**MODIFICATION APPLICATION (SSD 7173 MOD 3), PROPOSED STORMWATER CHANNEL  
REALIGNMENT & LOT 8 EXPANSION WORKS – FIRST ESTATE**

**PROPERTY AT: 579 & 585-649 MAMRE ROAD, ORCHARD HILLS (Lot 2 DP 1233392 & Lot 2171  
DP 1153854)**

**Table 1: Response Matrix**

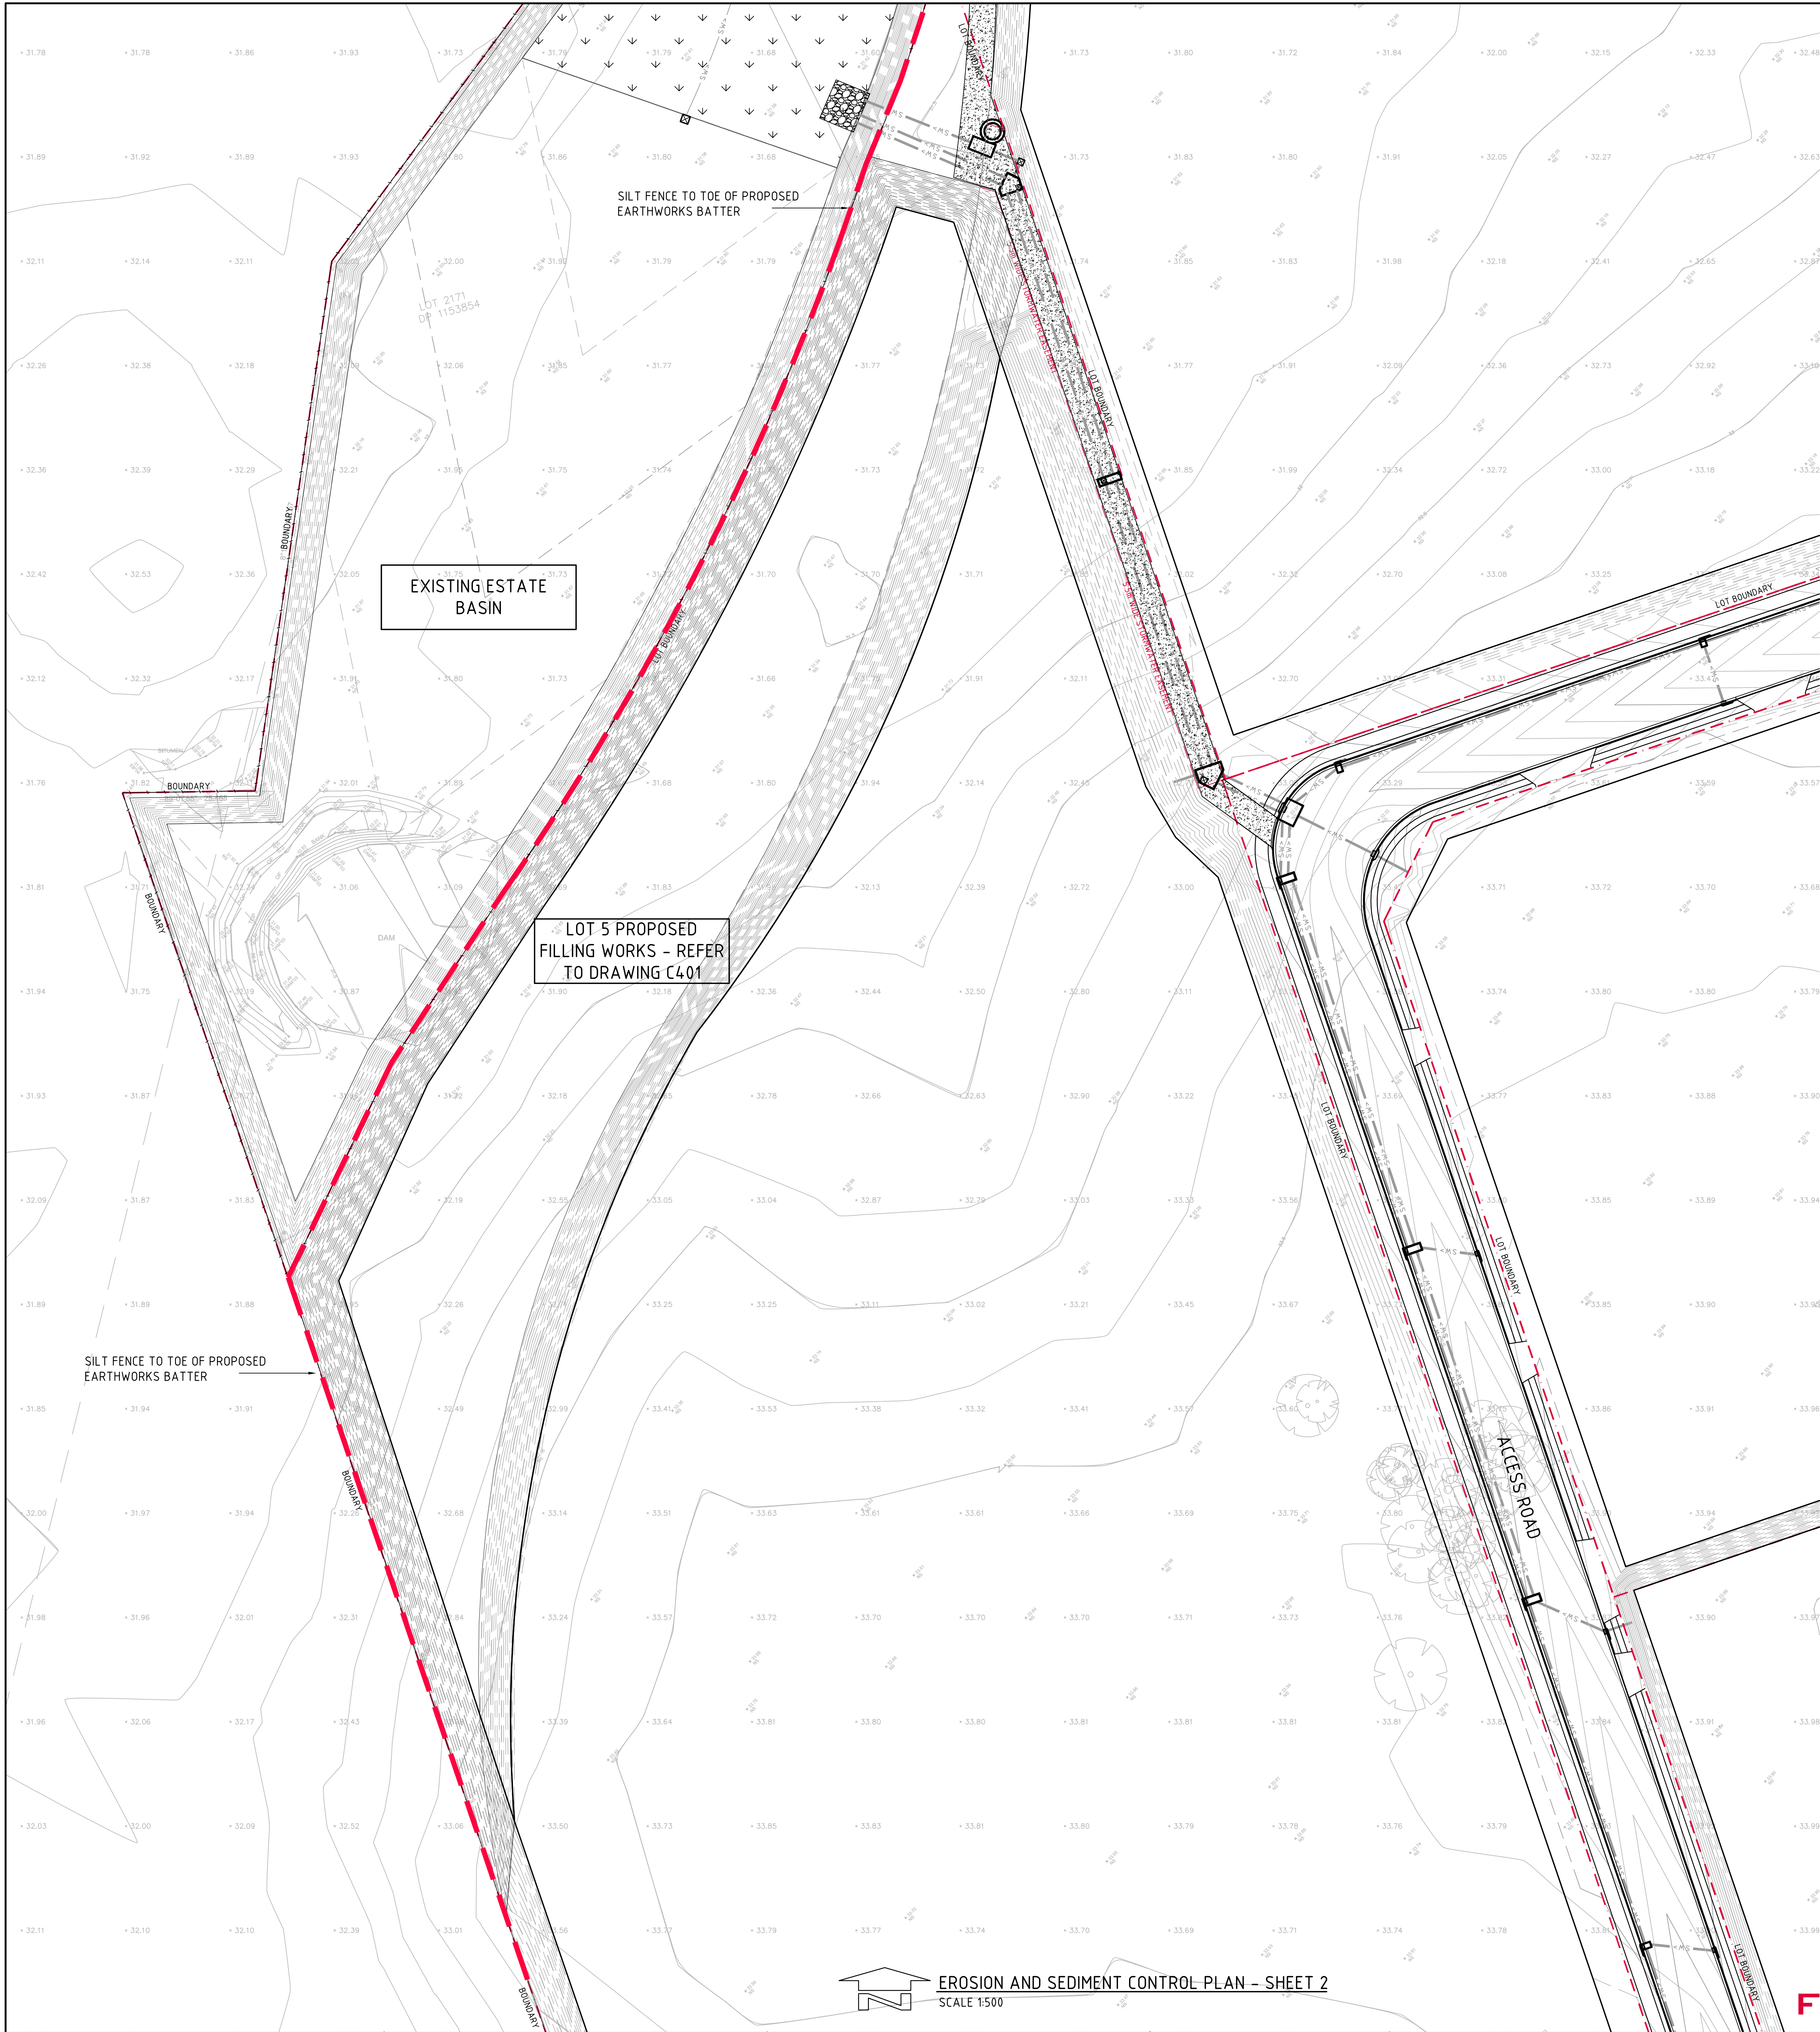
<b>NSW Office of Environment &amp; Heritage (OEH) (Susan Harrison – Senior Team Leader Planning)</b>	
<p><b><u>Construction of new channel</u></b></p> <p><i>The Modification report indicates the MOD 3 application proposes to construct a new drainage channel to replace the current realigned channel. In relation to the new channel, it is recommended:</i></p> <ul style="list-style-type: none"> <li>▪ <i>a fully vegetated riparian corridor is established along either side of the new channel (measured from top of bank) consisting of a diversity of local provenance native plant species from the relevant native vegetation community;</i></li> </ul>	<ul style="list-style-type: none"> <li>▪ Refer to updated Landscape Plan in <b>Appendix 2</b>.</li> </ul>

| <ul style="list-style-type: none"><li>▪ <i>local native grass species and native shrubs are established along the channel batters to assist stabilise the channel and improve habitat value; and,</i></li><li>▪ <i>the outlet of the new channel and bank of South Creek near the proposed works is revegetated with local native vegetation to improve habitat, stabilise the bank and mitigate the potential for scouring</i></li></ul> |  |

<p><b><u>Engineering Considerations</u></b></p> <p><u>Overland Flow</u>  <i>The Overland Flow Report prepared by Costin Roe Consulting, Revision D dated 8 June 2018 primarily focuses on an overland flow assessment to accompany the Mamre West – Stage 2 planning application and not focusing on the re-alignment of the channel for Stage 1. In this regard, an updated overland flow path analysis is required to be provided including an updated stormwater catchment plan. All details shall address the criteria required under section 2.4 of Council's Stormwater Drainage Policy.</i></p> <p><i>In addition to the above the extent and level of the 1% AEP local overland flows (pre and post) shall be shown on the site plan and all cross-sections.</i></p>	<p>Additionally, <b>Appendix 1</b> provides informed flood path analysis demonstrating the extent and level of the 1% AEP.</p>
<p><u>Drainage Easement</u>  <i>The drainage easement shall be created over the proposed channel within the adjoining downstream lot in accordance with Council's requirements. In this regard, the following criteria applies:</i></p> <ul style="list-style-type: none"> <li>▪ <i>Easement width shall be 1 metre plus top width of the 1% AEP design flow with 500mm freeboard;</i></li> <li>▪ <i>The subdivision plan shows '(L) proposed easement to drain Water 14 &amp; 35 Wide'. This shall be amended to state – 'Proposed Easement to Drain Water 14, 35 Wide &amp; Variable'; and,</i></li> <li>▪ <i>The subdivision plan shall show the existing drainage easement (G) on the plan to be deleted.</i></li> </ul> <p><i>All bio-swale / open channels should remain under the care and control of the registered proprietor of the lots benefited by the drainage easement, as Council will not accept any maintenance obligations or dedications.</i></p> <p><i>A turning head suitable for a maintenance and emergency vehicles is to be incorporated towards the western end of the 5m wide access trail and contained within the easement.</i></p>	<p>Costin Roe Consulting confirm that the easement width as nominated would be greater than the top width of the 1% AEP flow, with 500 mm freeboard plus 1 m either side. Confirmation of the width would be forthcoming in line with the Overland Flow Assessment required with regard to the above statement; and,</p> <p>With regard to the two (2) points concerning the subdivision, there is currently a Development Application (DA18/0674) being assessed and determined by Council that accurately addresses both points. Should further updates to the subdivision plan be made this can be provided as required (refer to <b>Appendix 4</b>).</p> <p>Maintenance obligations are noted regarding bio-swales and open channels within the bounds of First Estate. Furthermore, it is noted that the subject channel conveys runoff from Mamre Road (NSW RMS Road) and industrial land (approximately 9 hectares) to the east of Mamre Road (Goodman Estate) in addition to runoff conveyed from First Estate (both lots and roads). Notwithstanding, it is understood maintenance obligations relating the channel would be borne by the proponent (Altis Property Partners).</p> <p>An updated plan is located within <b>Appendix 1</b> to reflect the turning head for a B99 vehicle (large 4WD or similar maintenance vehicle). The turning head would be located in proximity to South Creek.</p>

<p><i>works and dedications, required to effect the consented development shall be undertaken at no cost to Penrith City Council;</i></p> <ul style="list-style-type: none"> <li>▪ <i>Owners consent is required for works proposed within the adjoining property of Lot 2, DP 1233392. A drainage easement shall also be created over the proposed channel within the adjoining downstream lot in accordance with Council's requirements; and,</i></li> <li>▪ <i>Prior to the issue of any Construction Certificate, the Principal Certifying Authority and/ or Certifying Authority shall ensure that an application under Section 68 of the Local Government Act, including payment of application and inspection fees, has been lodged with, and approved by Penrith City Council for the relocation of the open channel.</i></li> </ul> <p><i>Engineering plans are to be prepared in accordance with the development consent, Penrith City Council's Design Guidelines for Engineering Works for Subdivisions and Developments Engineering Construction Specification for Civil Works, Austroads Guidelines, and best engineering practice.</i></p>	<p>Refer to updated engineering plans in <b>Appendix 1</b>.</p>

Figure 3.2: Zones requiring revegetation in the VMP subject site.

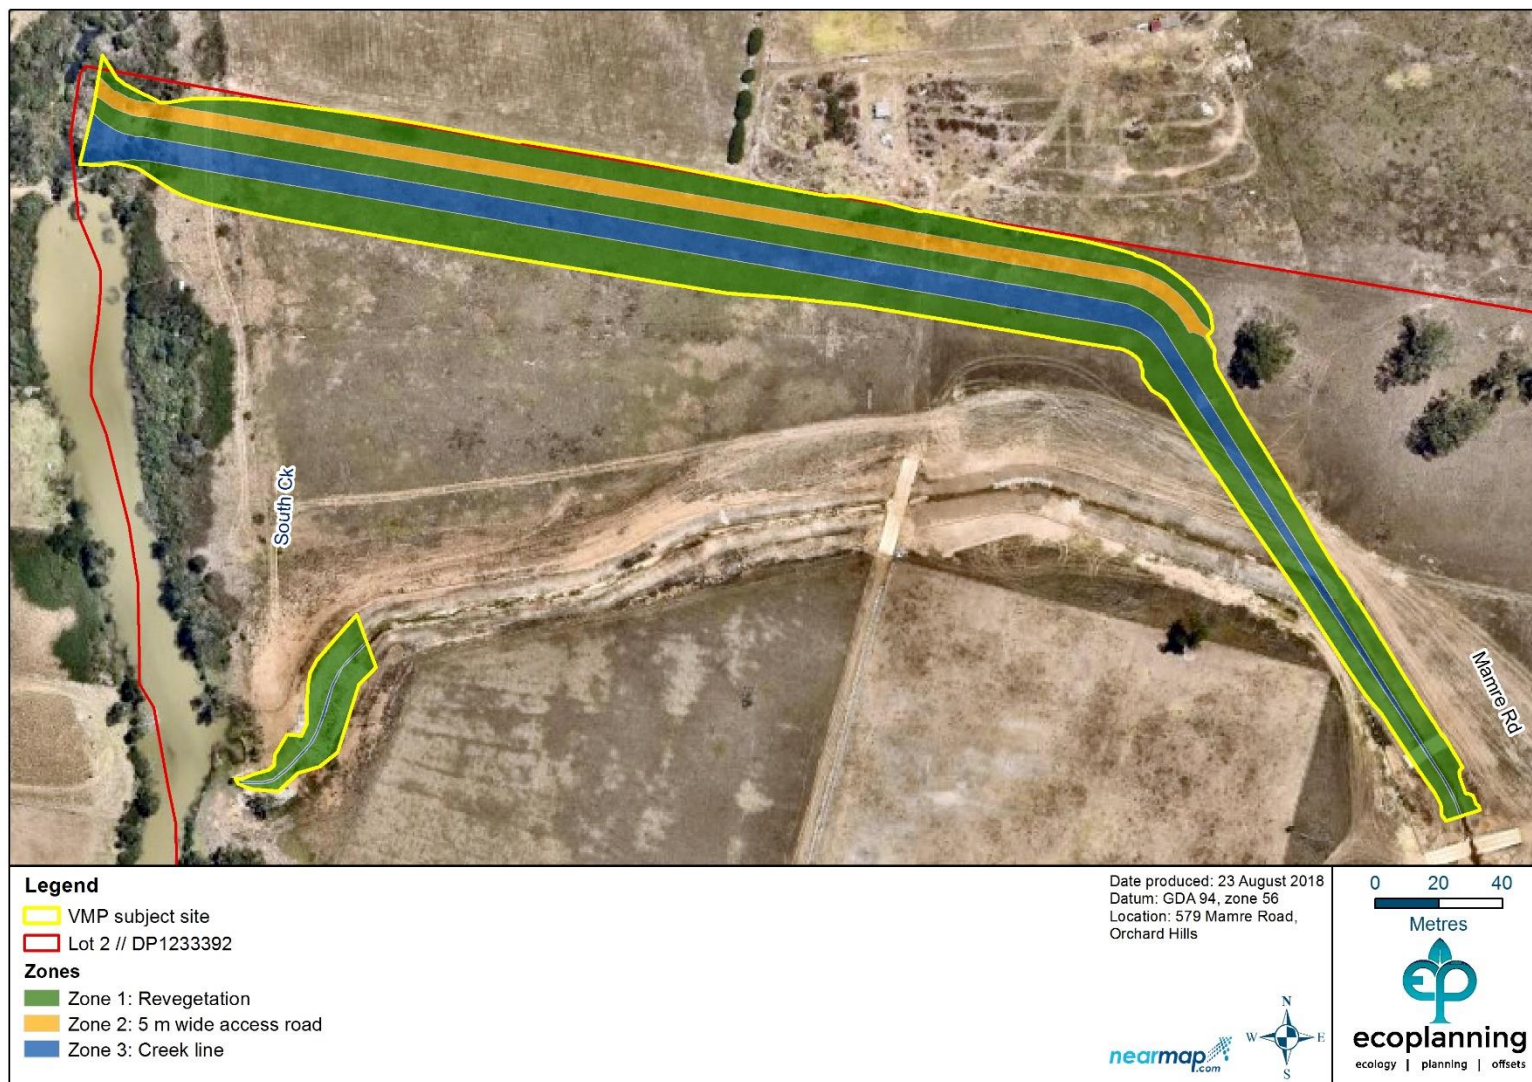
<p><b><u>Filling of the existing channel</u></b>  <i>In relation to the proposed filling of the existing channel to pre-existing levels, it is recommended:</i></p> <p><i>the riparian corridor along South Creek where the existing channel is proposed to be filled is revegetated with a diversity of local provenance native plant species from the relevant native vegetation community.</i></p>	<p>Refer to updated Landscape Plan in <b>Appendix 2</b>.</p>
<p><b><u>Preparation of a Vegetation Management Plan</u></b>  <i>If the modification application is approved, it is recommended a condition of consent is included to prepare a Vegetation Management Plan (VMP) to address the above issues and provide details on the rehabilitation of a vegetated riparian corridor along either side of the new channel and the riparian areas disturbed along South Creek including:</i></p> <ul style="list-style-type: none"> <li>▪ <i>the proposed vegetation (such as plant species/communities, spacings, tubestock / virocells / long stems / direct seeding, etc.);</i></li> <li>▪ <i>maintenance of the vegetation (such as maintenance period, watering, replacement of plant losses, weed control etc);</i></li> <li>▪ <i>the monitoring and review of the vegetation;</i></li> <li>▪ <i>the long-term protection and maintenance of the vegetation; and,</i></li> <li>▪ <i>the provision of a permanent physical barrier (such as a fence/bollards etc), to prevent inadvertent damage to the riparian vegetation.</i></li> </ul>	<p>It is acknowledged that as a condition of the Modification Application being approved, that the requirement for a Vegetation Management Plan (VMP) would be required to address the construction of the new channel, as-well-as filling of the existing channel. Additionally, details would be required that demonstrate the rehabilitation of a vegetated riparian corridor along either side of the new channel and the riparian areas that would be potentially disturbed as a result of the proposed development (refer to <b>Appendix 2</b>).</p> <p>A comprehensive VMP has been accordingly provided by Ecoplanning, which addresses the adjacent column imposed by OEH (refer to <b>Appendix 5</b>).</p>
